EP/81/19/L

The application is for an Orangery to replace an existing rear conservatory at Wisteria Cottage.

# ORANIERY DESIGN

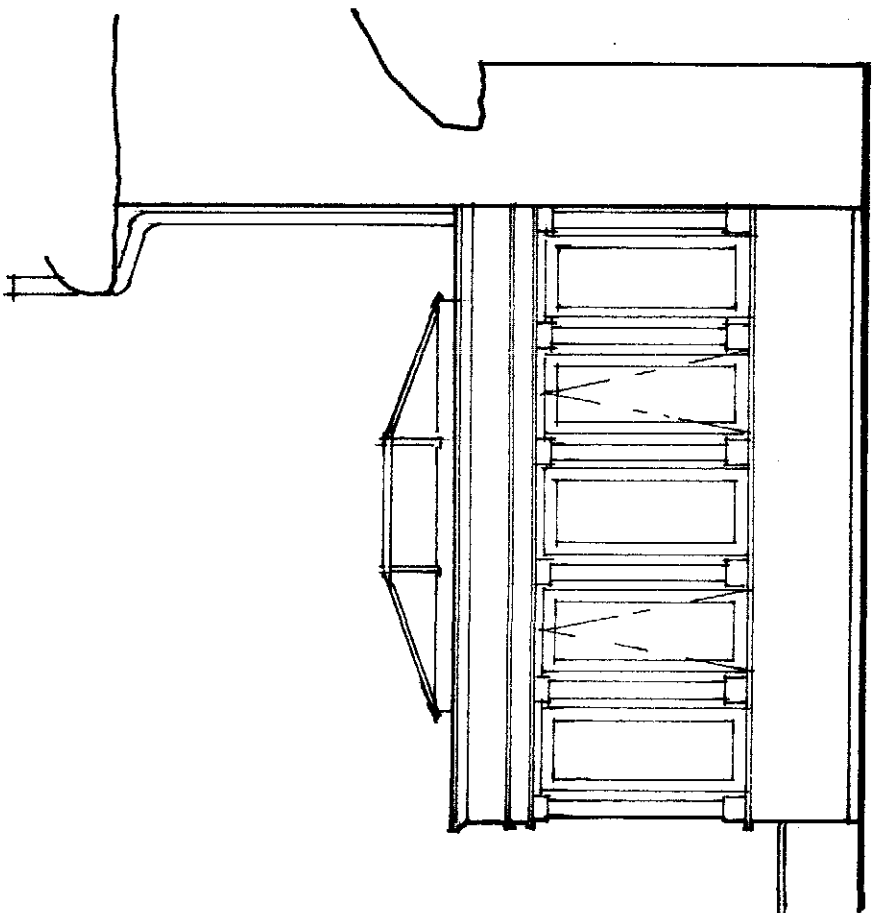
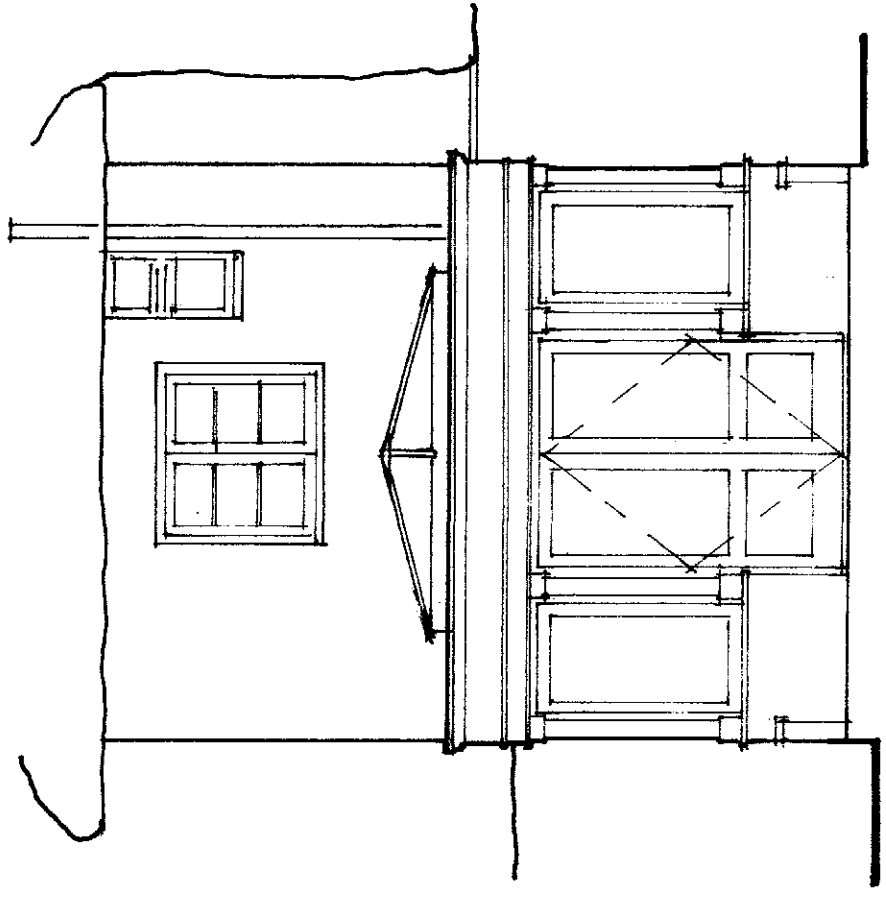
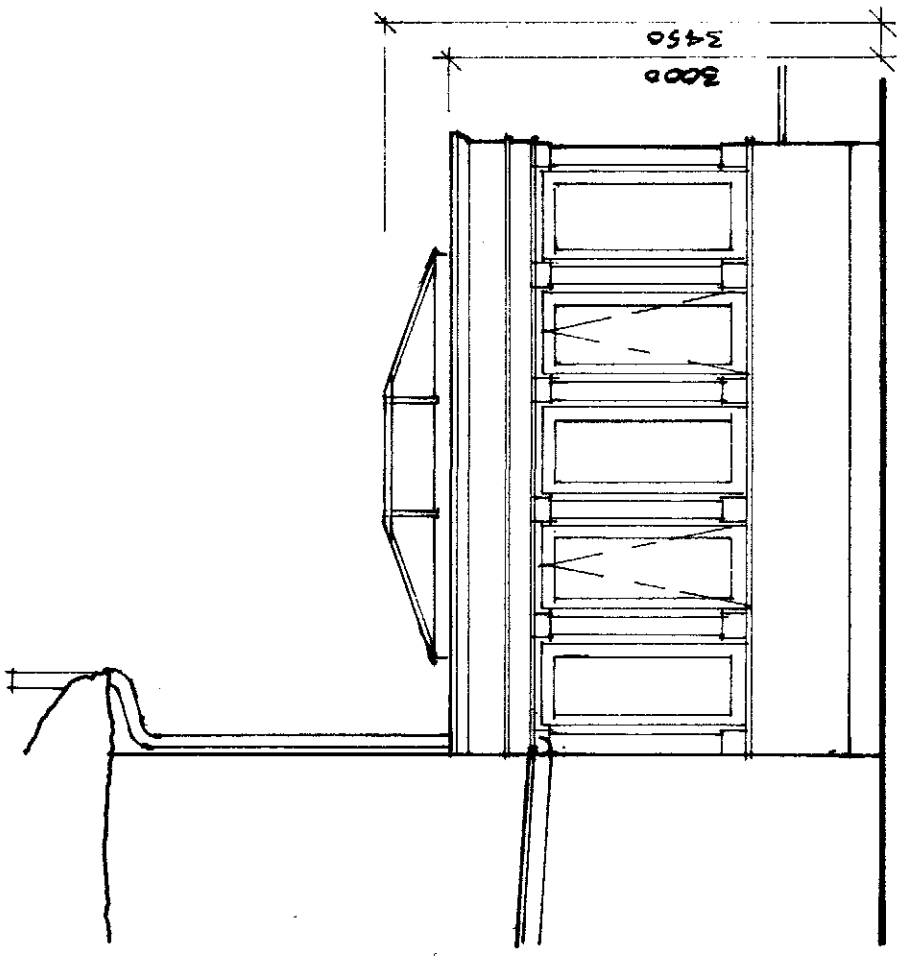
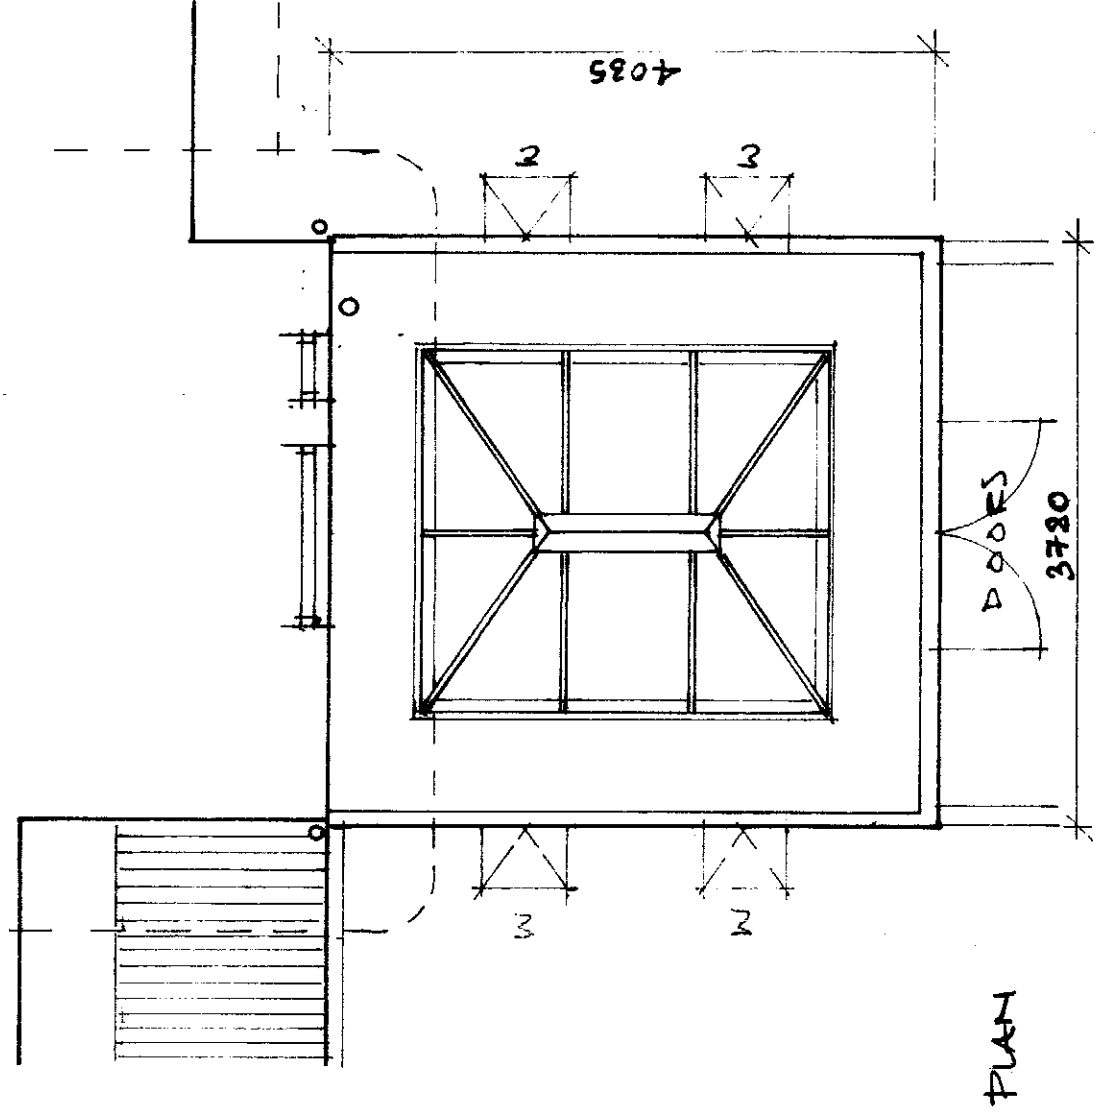
I note that the replacement structure will occupy the same space and utilise the existing brick walls. The replacement structure will respect the existing host dwelling and be treated so as to not cause harm to the host dwelling. Further, whilst it would be partly visible from the street, it will have no greater impact than the existing structure.

It should be noted that any works of repair that are undertaken to the section of flint wall above the orangerie should use materials appropriate for the listed building.
